Our ref: Oxley Solar Farm (SSD-10346)

02/12/2022

Subject: Request for Additional Information

Concept Design for Upgrade of Gara Road Causeway

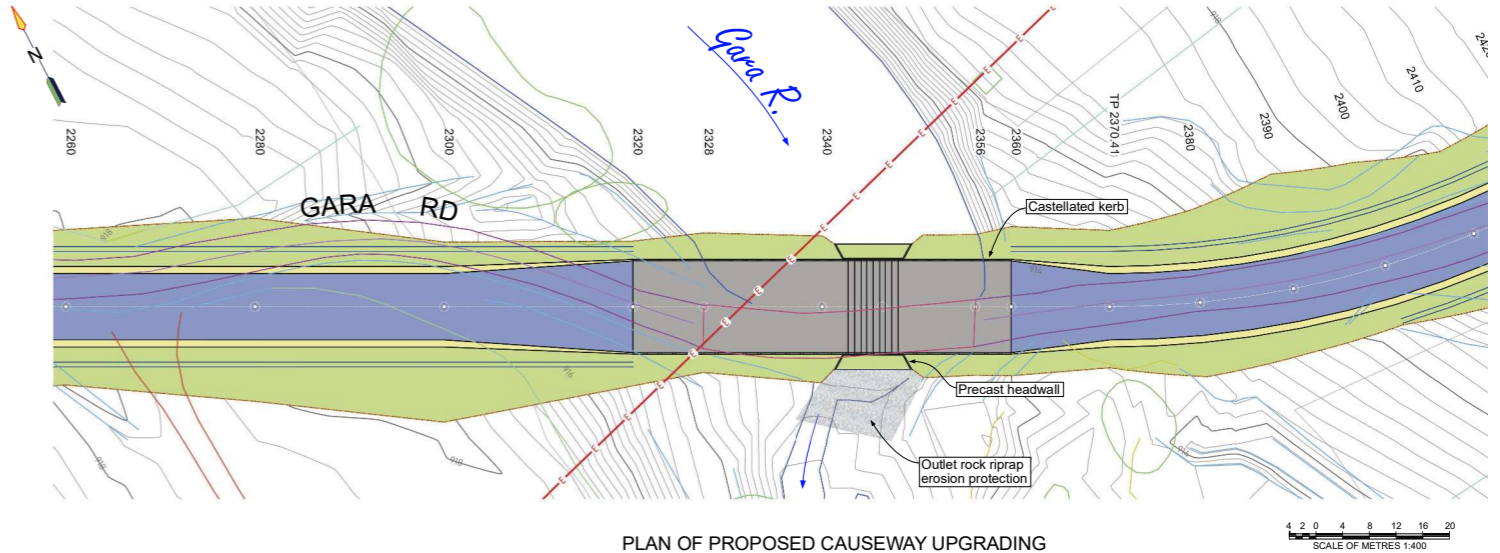
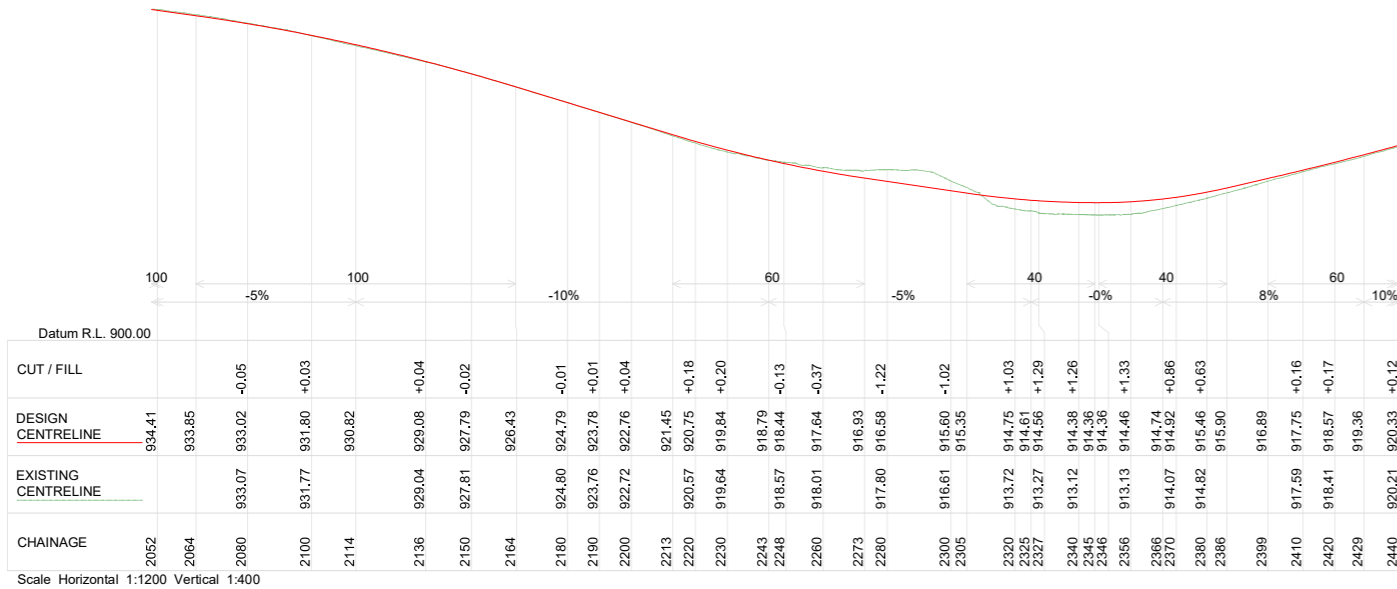
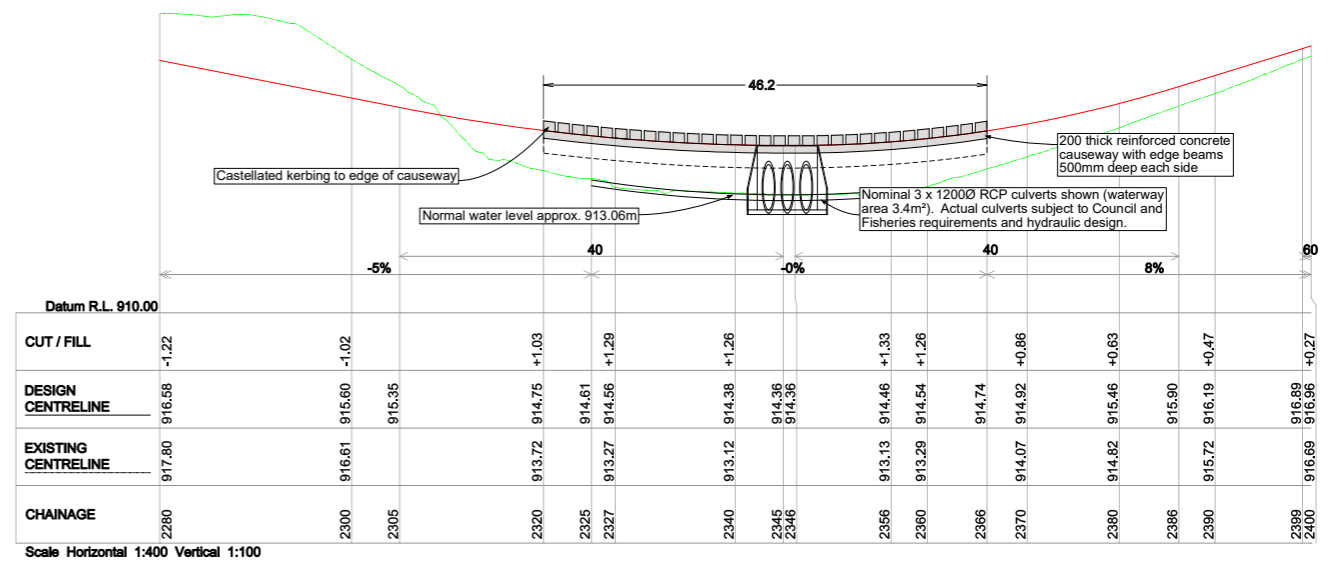
- confirm that the upgrade of Gara Road causeway would be in accordance with relevant NSW Fisheries guidelines, including the removal of the existing causeway and the construction of an appropriately designed multi-cell box culvert structure or alternatively a bridge to ensure that fish passage is maintained or enhanced at this site. Provide this information and confirm level of assessment undertaken, including hydrological assessment of the causeway in determining the upgrade specifications to the causeway; and
- confirm sufficient access to water entitlement by identifying potential sellers or available entitlements to trade with.

Figure 2 Armidale Regional Landfill Access Road

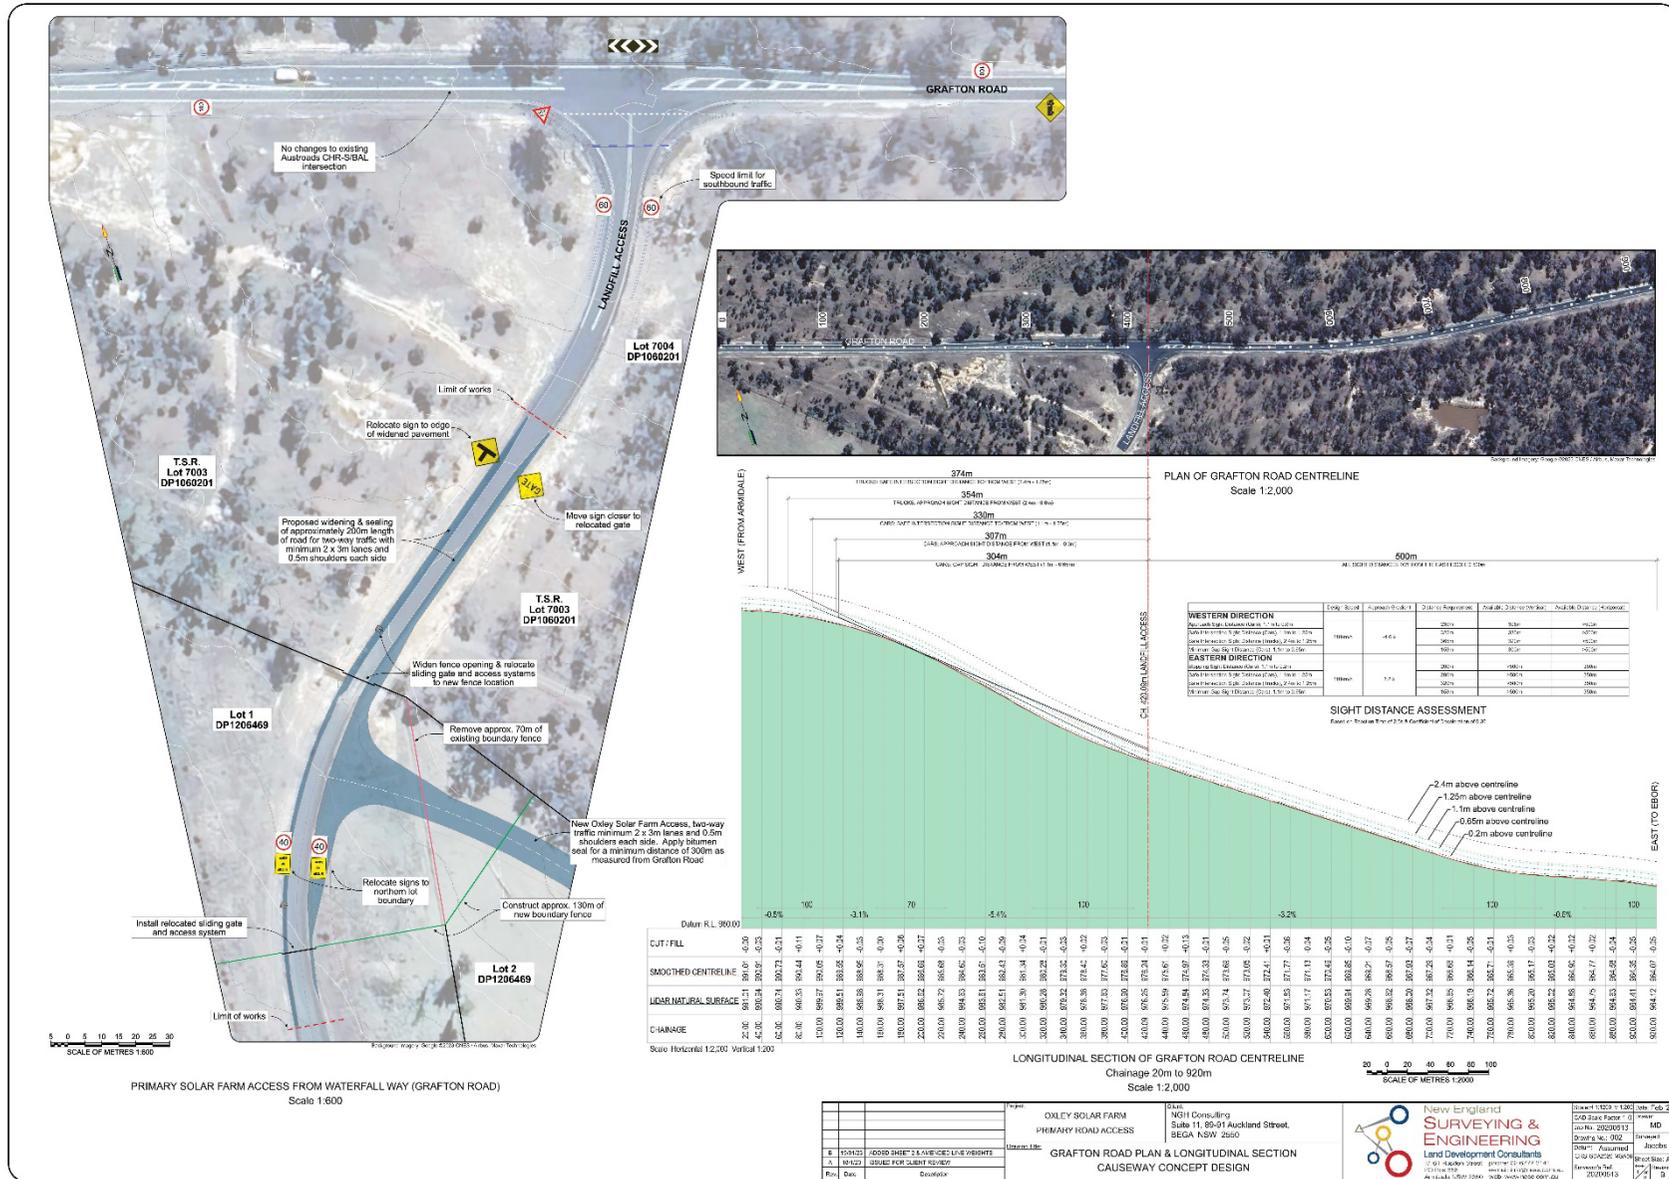
- provide a scaled strategic design illustrating the full scope of road works at the Armidale Regional landfill access road that demonstrates the required Safe Intersection Sight Distance (110 km/h design speed) and swept path analysis for the largest vehicles accessing the project site;
- clarify the anticipated vehicle numbers, vehicle dimensions and overall mass of containers being transported to site, including swept path for all vehicle dimensions
